A585 Windy Harbour to Skippool Improvement Scheme ("the Scheme")

A585 Windy Harbour to Skippool Improvement Scheme
Reference TR010035
Proposed Design Changes and Additional Land

| Drawing number | HE548643-ARC-HGN-SZ_ZZ_000-DR-4035 | | |

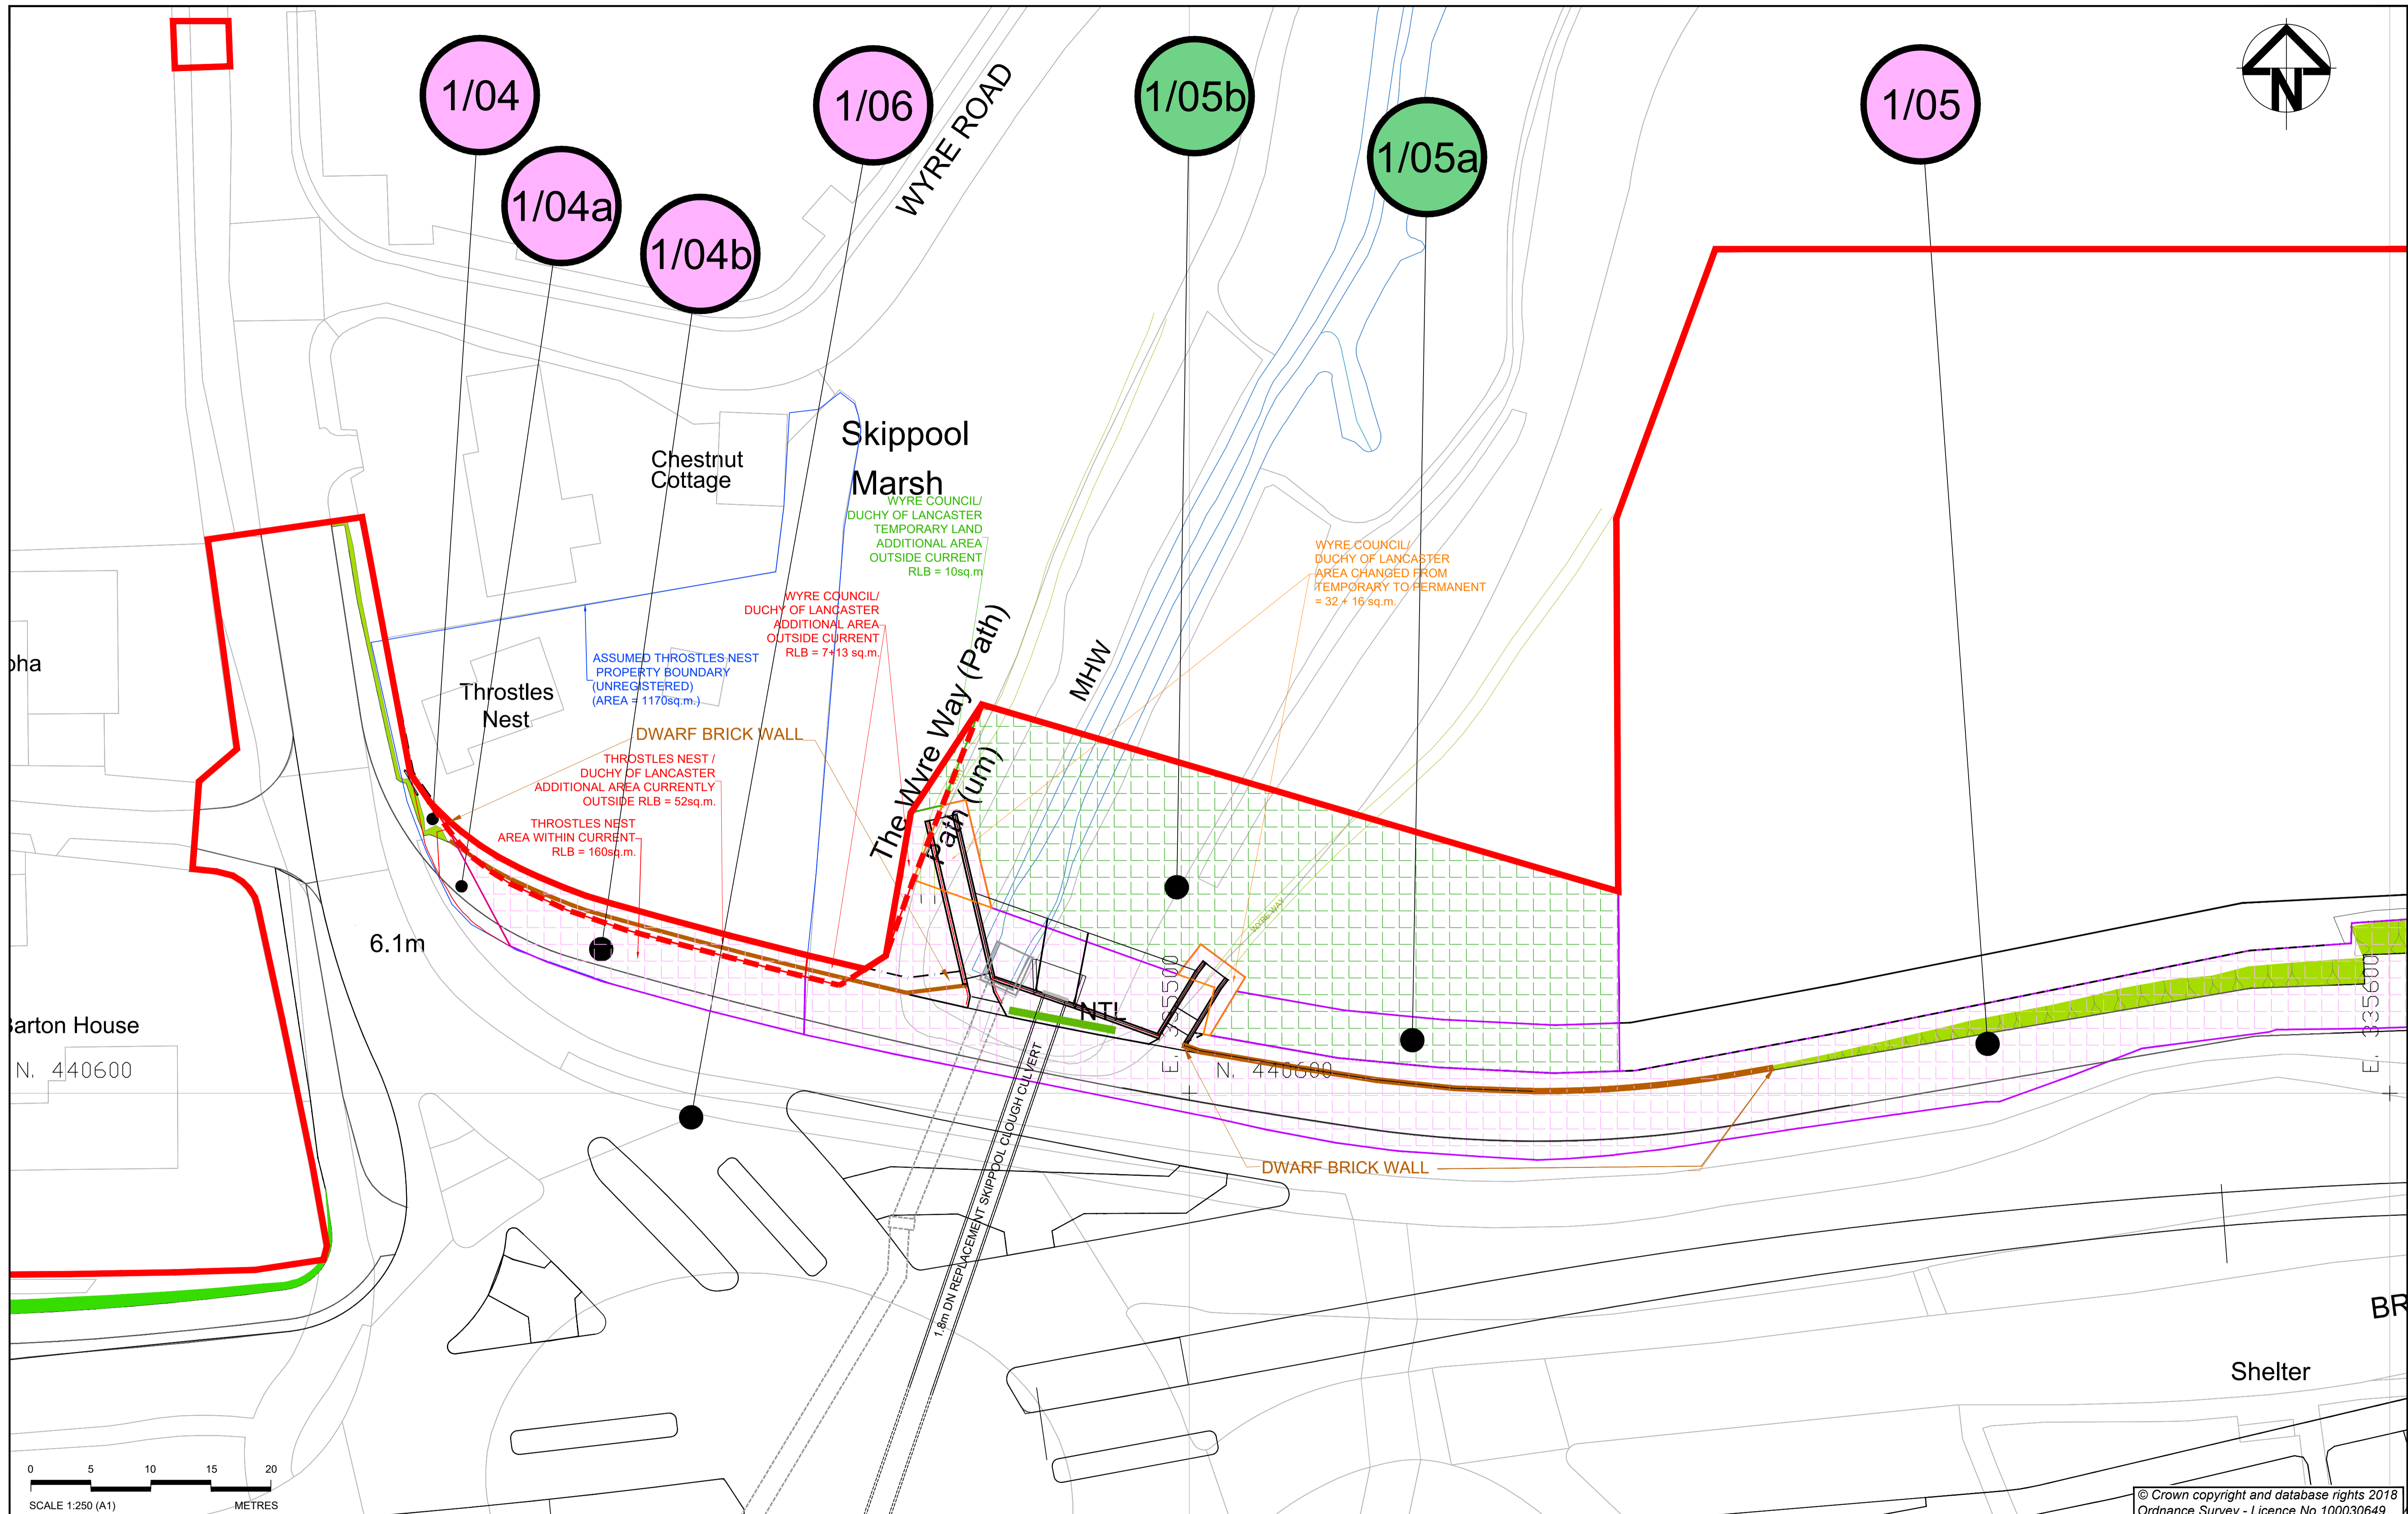
Following further engagement with various statutory bodies, Highways England has been requested to make changes to the Scheme, including construction of a dwarf wall and widening of the northern footway/cycleway from Skippool Road. The dwarf wall will provide flood protection and the widening of the footway/cycleway will accommodate the diversion of utilities. The proposed changes are shown on the enclosed drawing (HE548643-ARC-LLO-SZ_ZZ000DR-D-3017).

| Drawing number | HE548643-ARC-HGN-SZ_ZZ_000-DR-4034 | | |

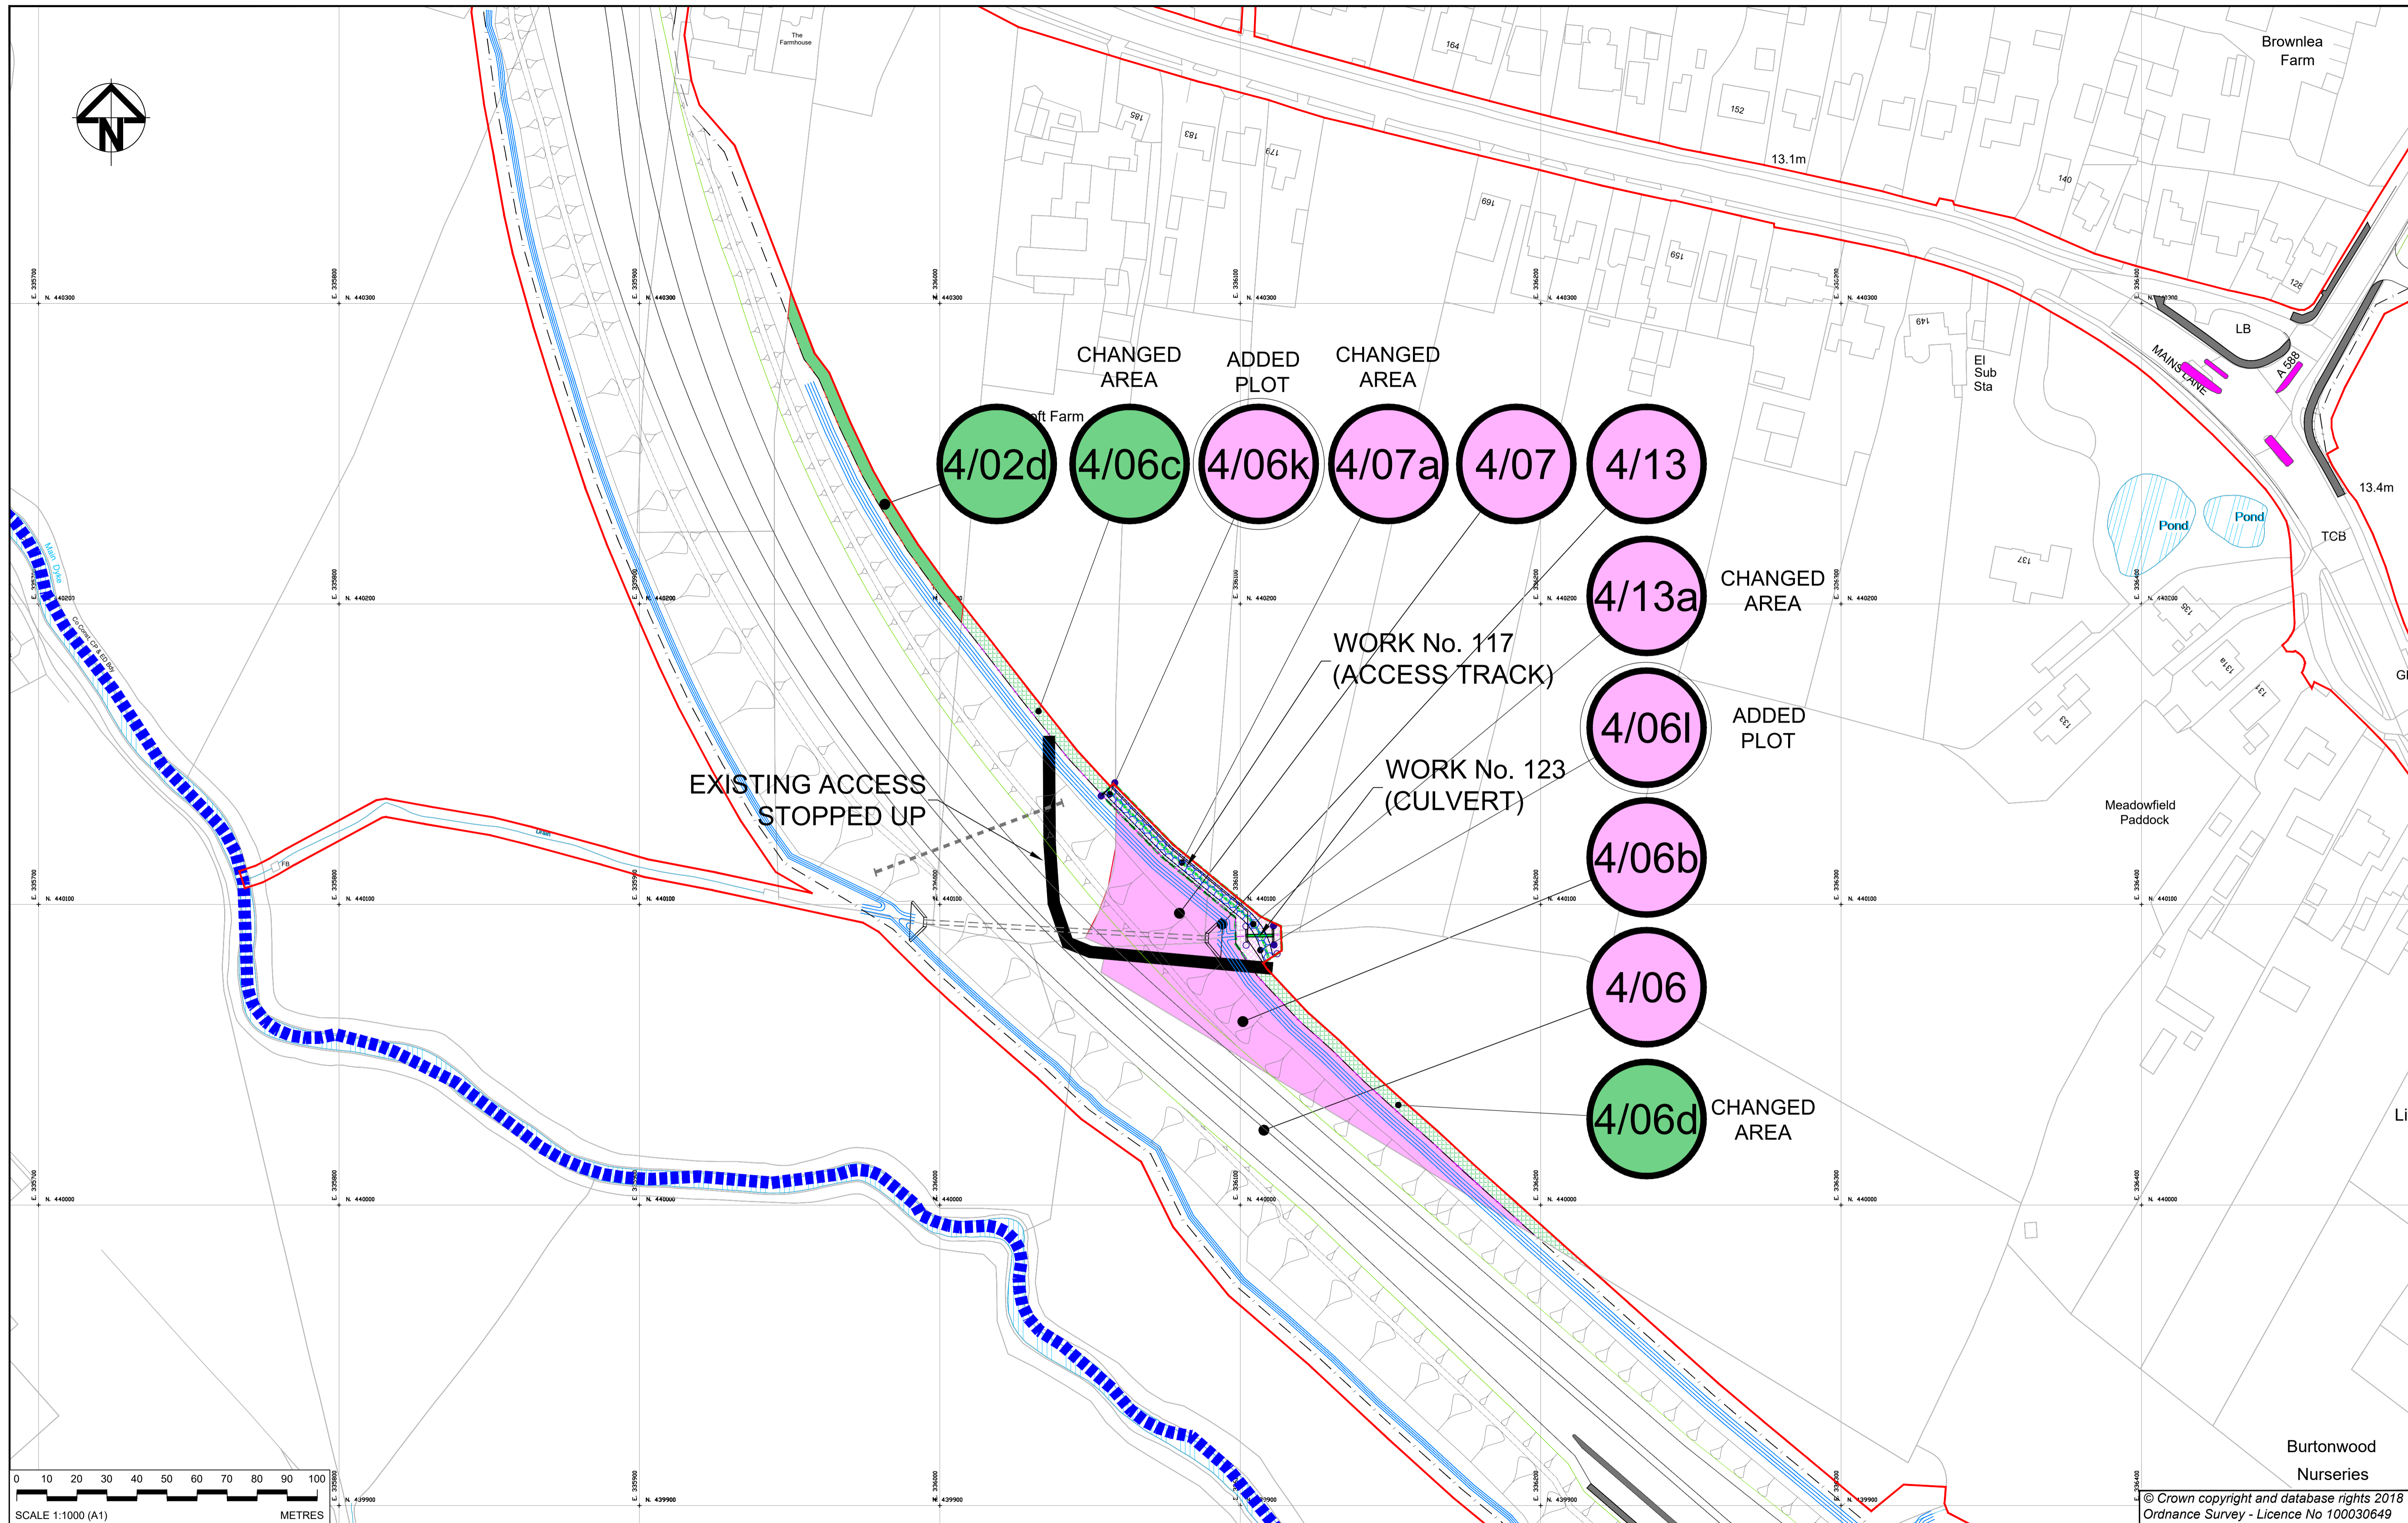
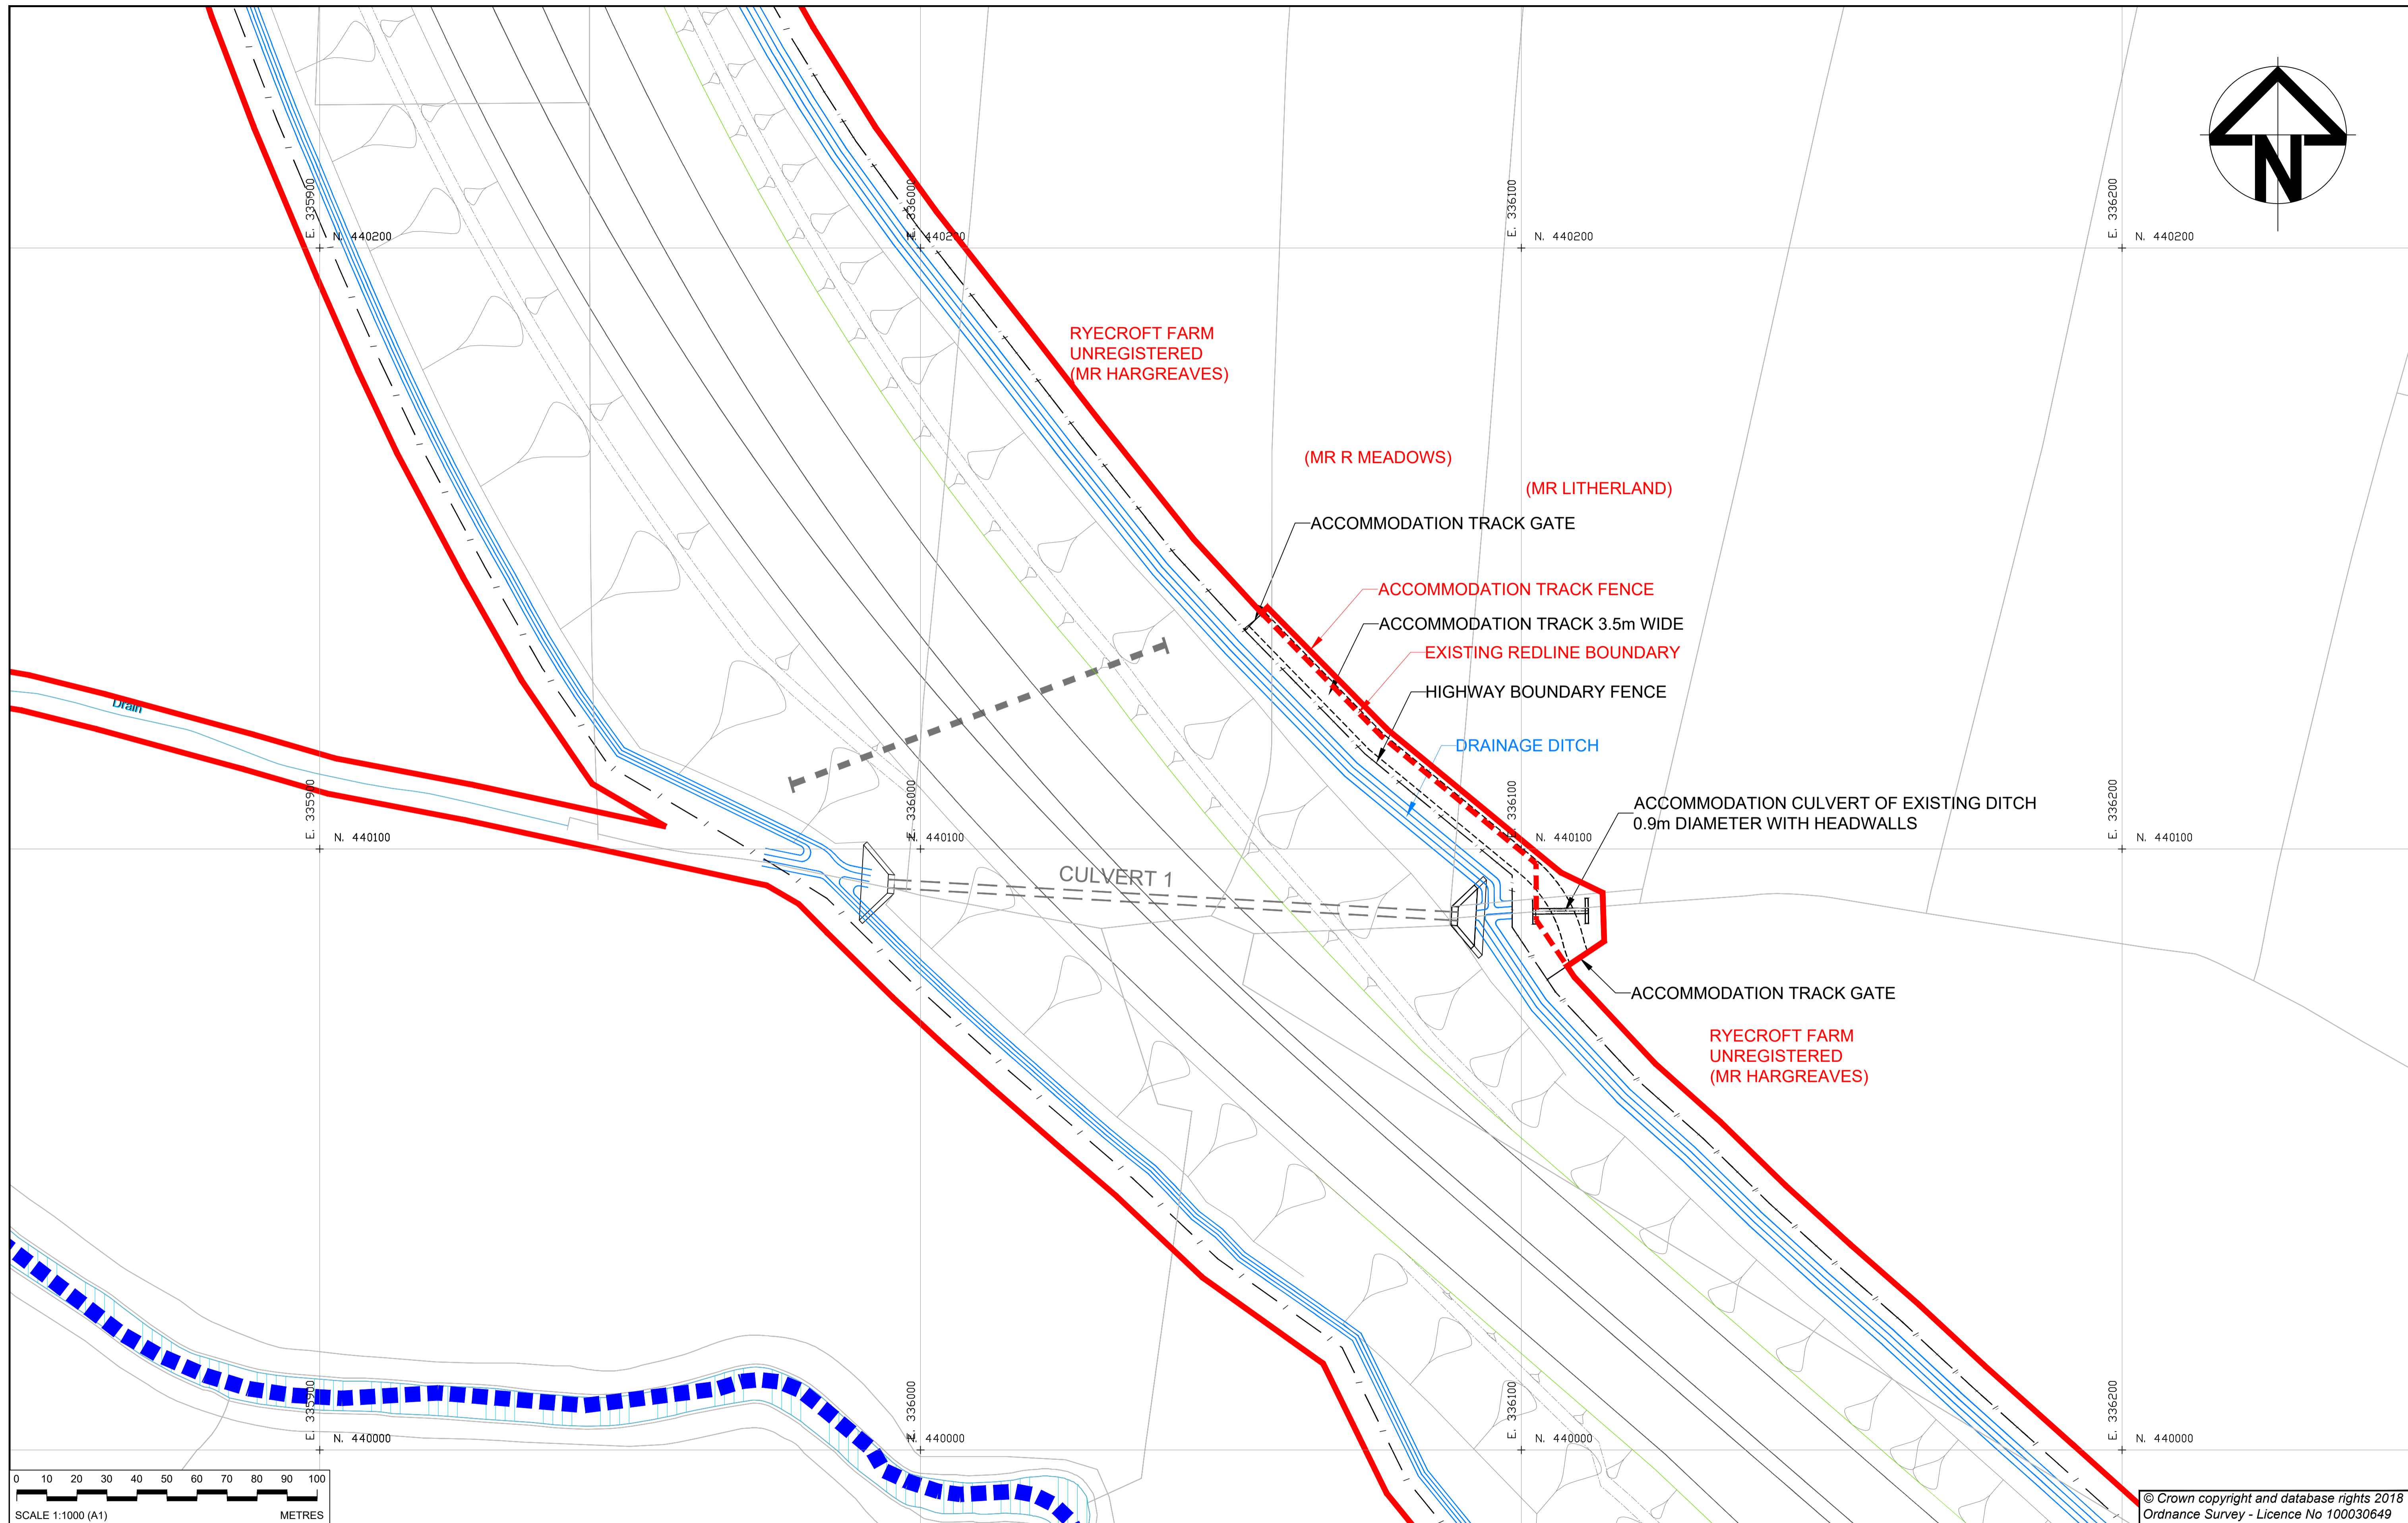
Further to a request from the landowner seeking plots of land to the north of the Scheme to remain connected once the bypass is constructed, Highways England is proposing to make various changes to the Scheme within the vicinity of this plot of land, including:

- Provision of a link to the main farm land with the plot to the north-east of Culvert 1 as the bypass severs the northern land parcel
- Construction of a farm access track 3.5m wide within a nominal width of 5.5m
- Provision of accommodation fencing on the north side of the access track
- Provision of farm gates at both ends of the access track
- Provision of an accommodation culvert (0.9 metre diameter) across the ditch to the north-east of Culvert 1
